Scheme: EWR2 Compound A1 Access

# Technical Audit

Reference: 272.13

Date: 20/1/20

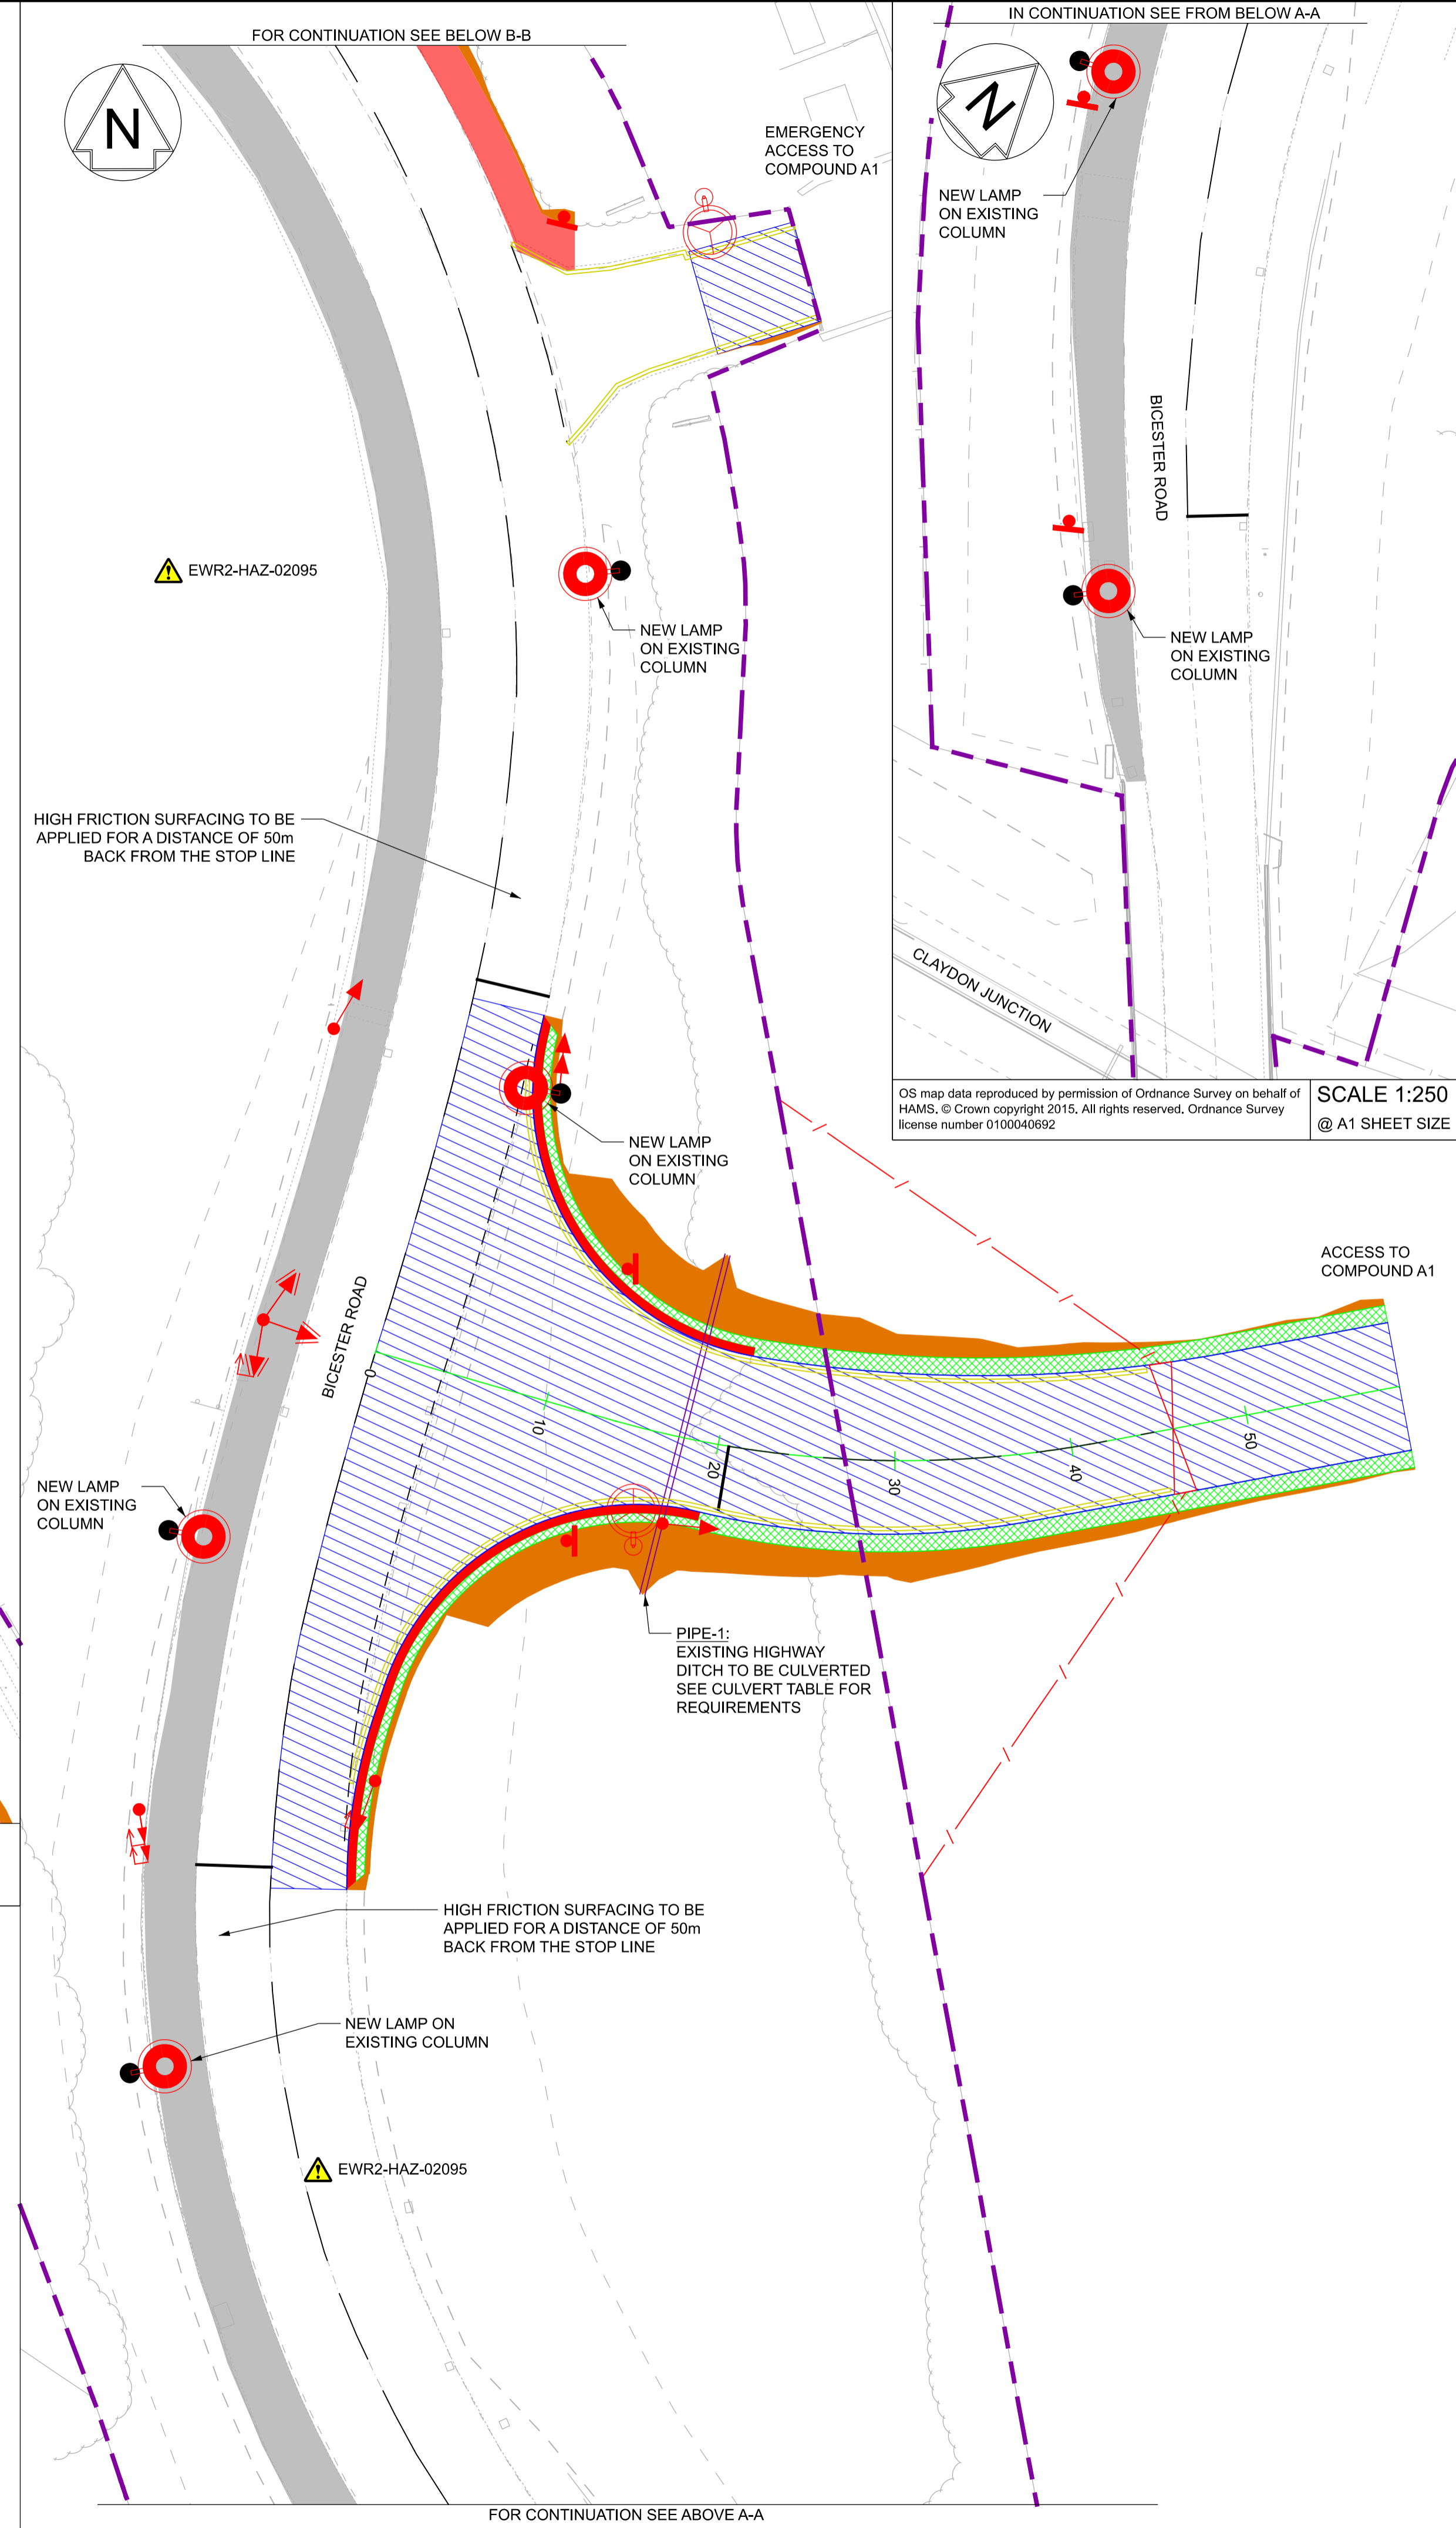
<p><b>Drawing No. – 002001 GA</b></p> <ol style="list-style-type: none"> <li>1. In lieu of a separate drainage plan please show the proposal for relocating the existing gullies in the middle of the new access.</li> </ol>	<ol style="list-style-type: none"> <li>1. The current proposals include temporary removal of the existing gullies during operation of the site, and these gullies will be reinstated when the compound access is</li> </ol>

<ul style="list-style-type: none"> <li>2. Additional area of highway within the new access will mainly run into the site. Please show provision for discharging this run-off</li>   <li>3. Please show surfacing types and extents or include an additional drawing for these.</li>   <li>4. Access construction to be agreed – EWR2 want concrete within highway but OCC reluctant. TBC following detailed design from Atkins</li> </ul>	<p>decommissioned. The proposed temporary access road falls away from Bicester Road, so there will be no additional surface runoff entering the remaining existing gullies along Bicester Road.</p> <ul style="list-style-type: none"> <li>2. Drainage drawings 133735_RW-EWR-XX-A1-DR-DH-001101 to 001103 (included) show the proposed drainage system within the temporary compound. It should be noted that the section of the proposed temporary access road within the highway boundary will have over the edge drainage into the existing highway drainage ditch. The temporary access road outside highway boundary will have separate drainage system that will capture runoff and attenuate it to greenfield rates before outfall to a watercourse to the east of the proposed compound.</li>   <li>3. Pavement layout drawing 133735_2A-EWR-OXD-CC_A1-DR-CH-002019 is included and shows the types and extents of the proposed pavements.</li>   <li>4. Compound access construction is proposed as Type F5 Flexible construction shown on drawing 133735_RW-EWR-XX-XX-DR-CH-000215 which is included.</li> </ul>

Drawing Number 133735_2A-EWR-OXD-CC_A1-DR-CH-002101

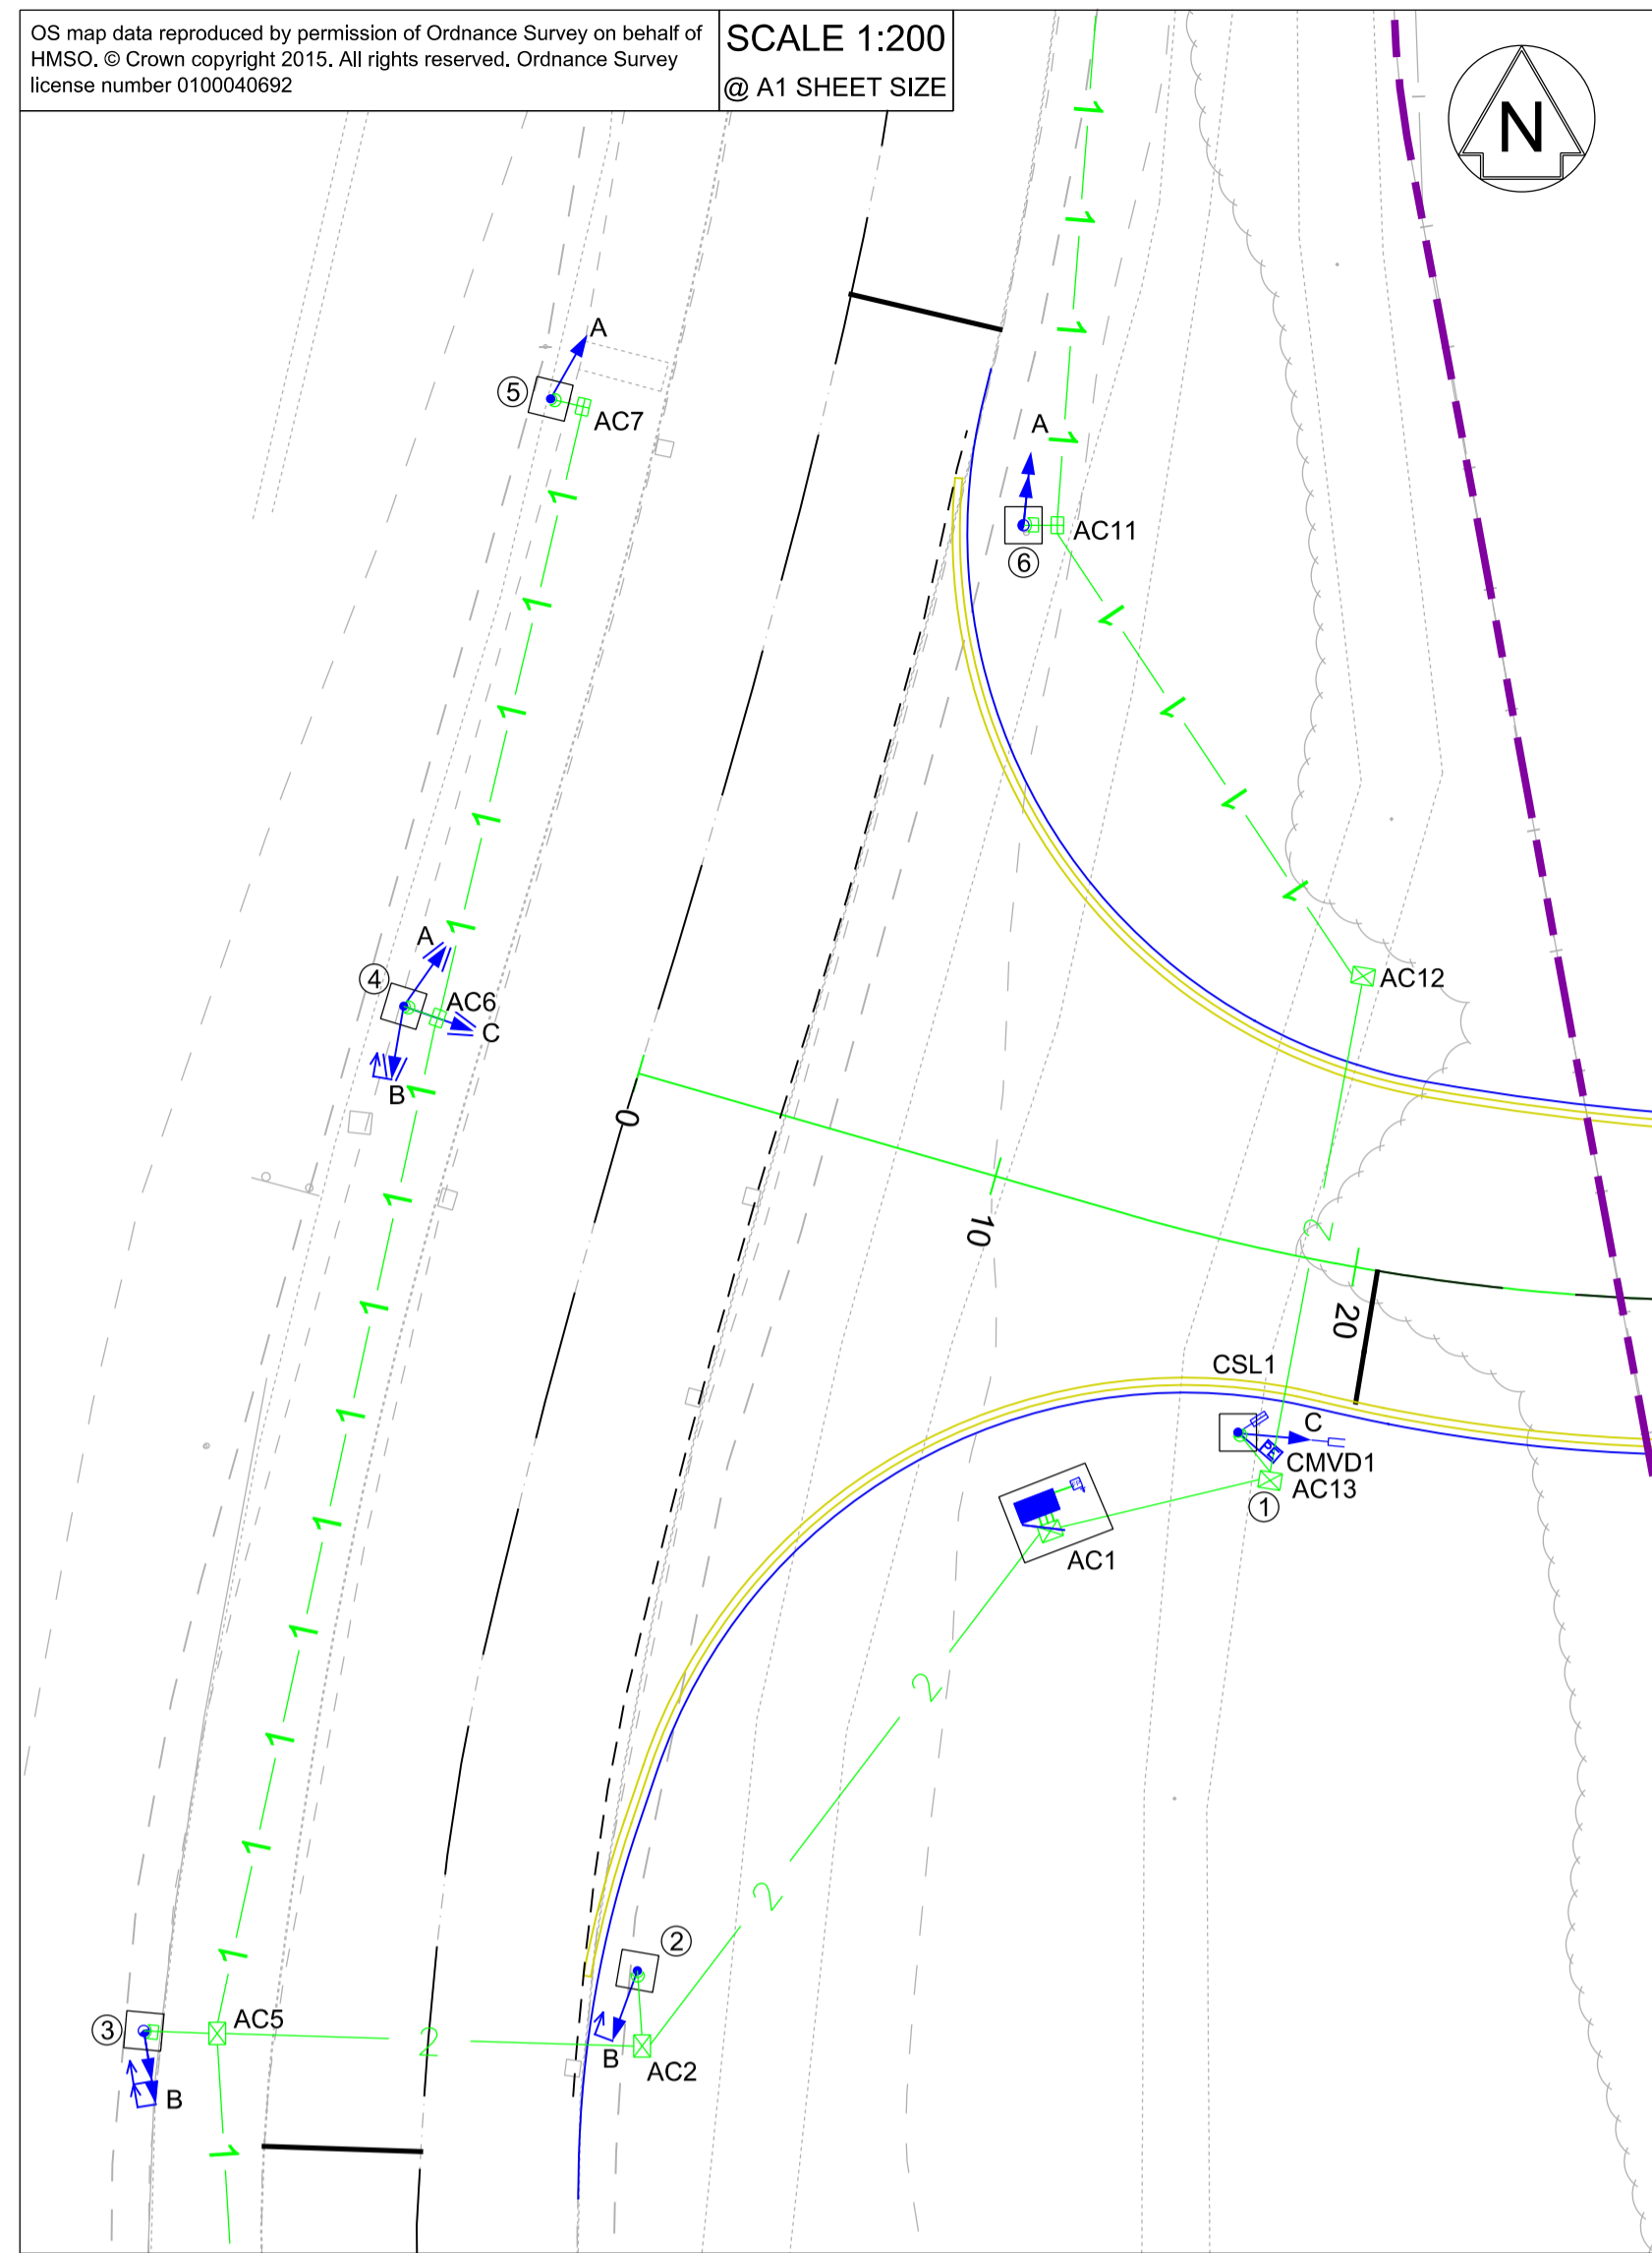
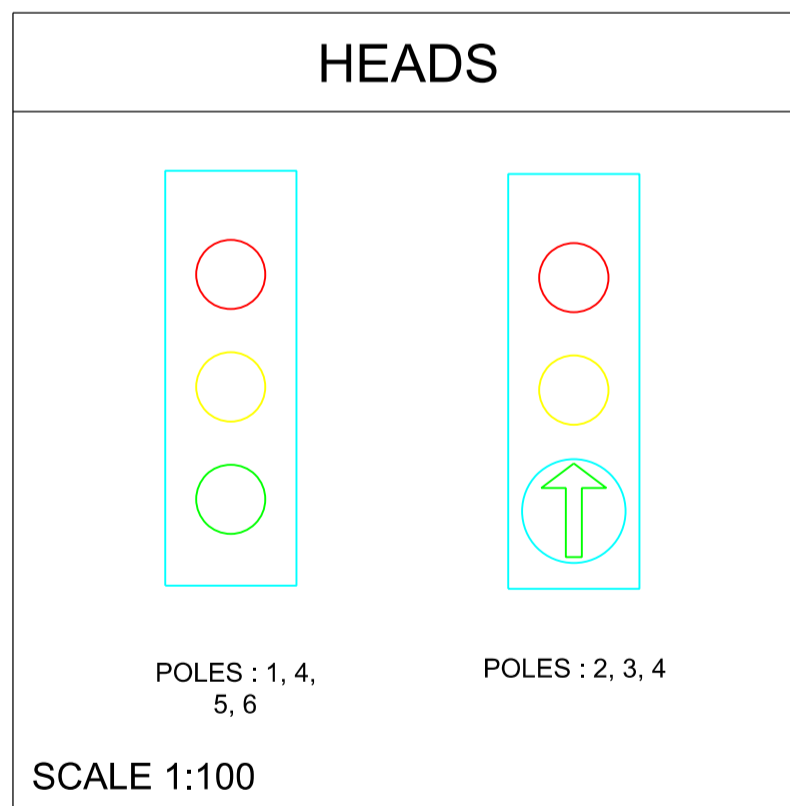
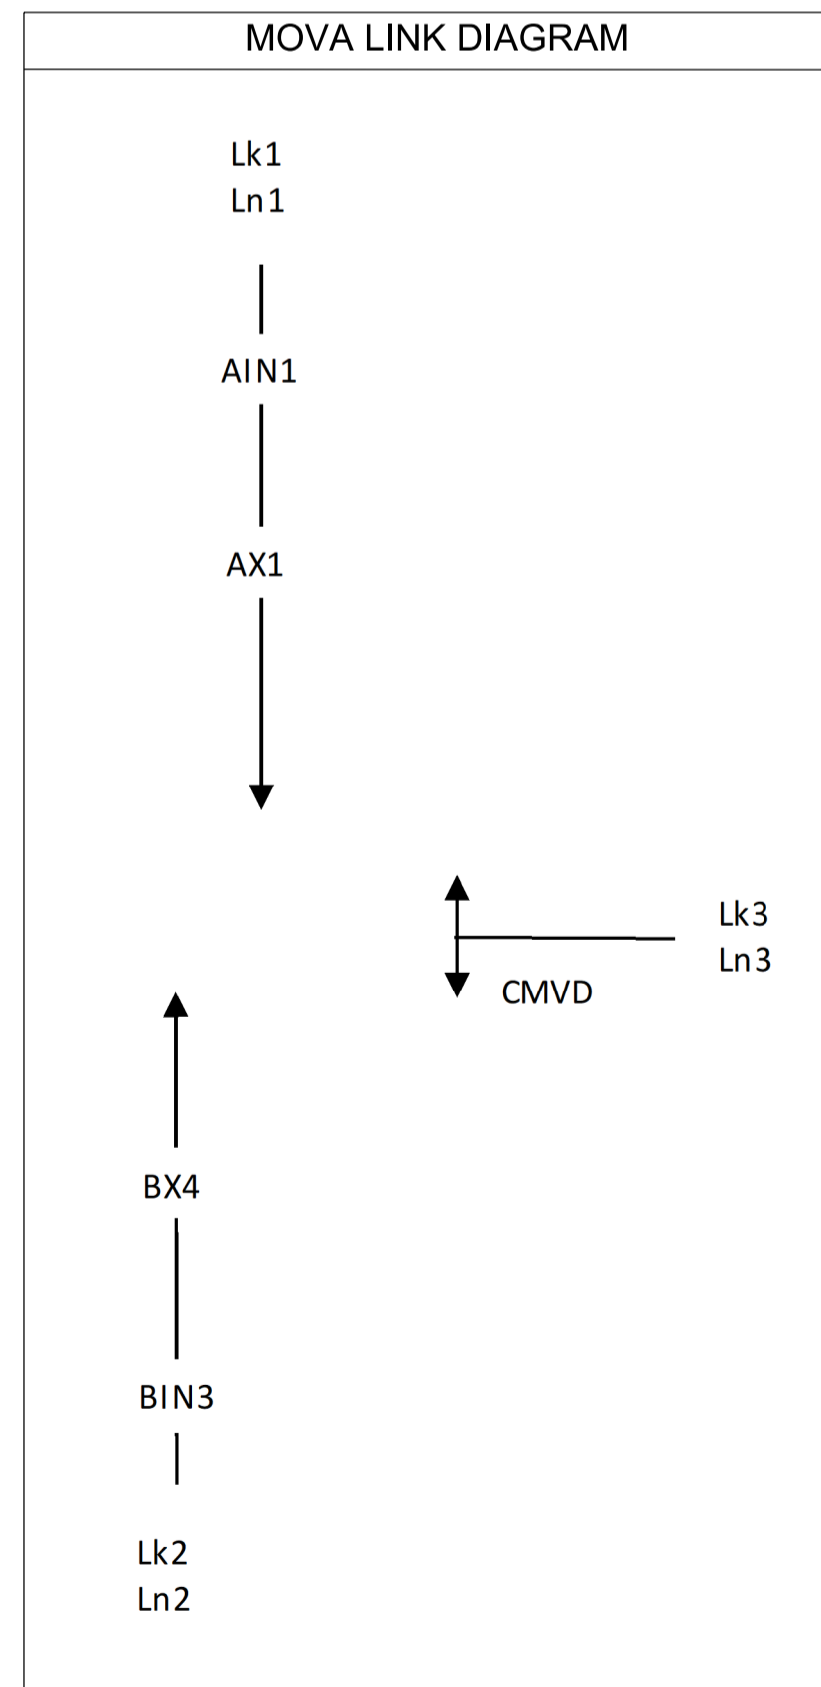
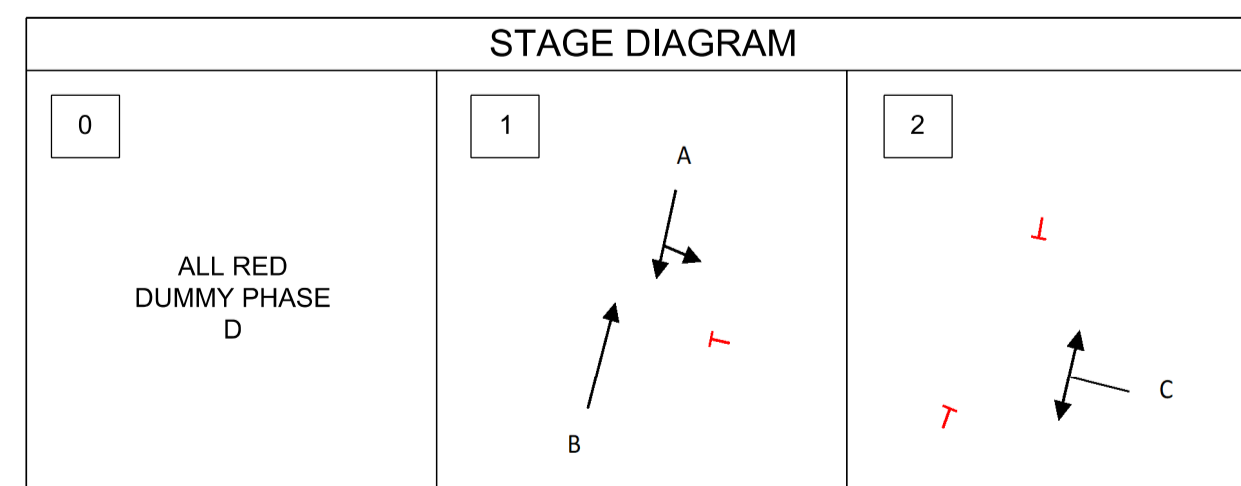
<p><b>Drawing No. – 002101</b></p> <ol style="list-style-type: none"> <li>OCC Signals team need more detail and appendix 12/5 plus 2500 specification etc. Nick Marceta from OCC is liaising with Mike Flynn from Atkins</li> </ol>	<ol style="list-style-type: none"> <li>The signals information is included. Nick Marceta has had a copy of this.</li> </ol>
<p><b>Drawing No. – 000147 / 148</b></p> <ol style="list-style-type: none"> <li>Depending upon what is agreed with OCC Asset team re. construction of access, please remove whichever construction Type is not needed to avoid confusion</li> <li>Concrete Type F2 detail needs more information on the joint detail to specify how the movement of the slab can be accommodated without damaging the main road or leaving a large gap to collect water. It would also need a note to state that a detailed assessment of existing road construction at that location is required to determine whether or not the slab can abut the asphalt without localised edge strengthening</li> <li>Flexible Type F1 might need to be low void SMA or possibly AC10 surfacing in order to tie in better with existing road surface depending upon what is there currently. Please add a note to assess the current surfacing with OCC inspector. Also, the high-stone HRA would be ideal on the access road but would lack the necessary skid resistance at the tie-in point on the main road.</li> <li>Please show tie-in for flexible extending the surfacing to half-width (i.e centreline) for the flexible detail</li> </ol>	<ol style="list-style-type: none"> <li>Temporary flexible pavement construction, Type F5, is proposed.</li> <li>Resolved due to using Type F1 construction.</li> <li>No objection to using 0/10 SMA. Flexible pavement type F5 has been produced and is shown on Standard detail drawing 133735_RW-EWR-XX-XX-DR-CH-000215.</li> <li>Standard detail drawing 133735_RW-EWR-XX-XX-DR-CH-000215 has the requested tie-in detail.</li> </ol>
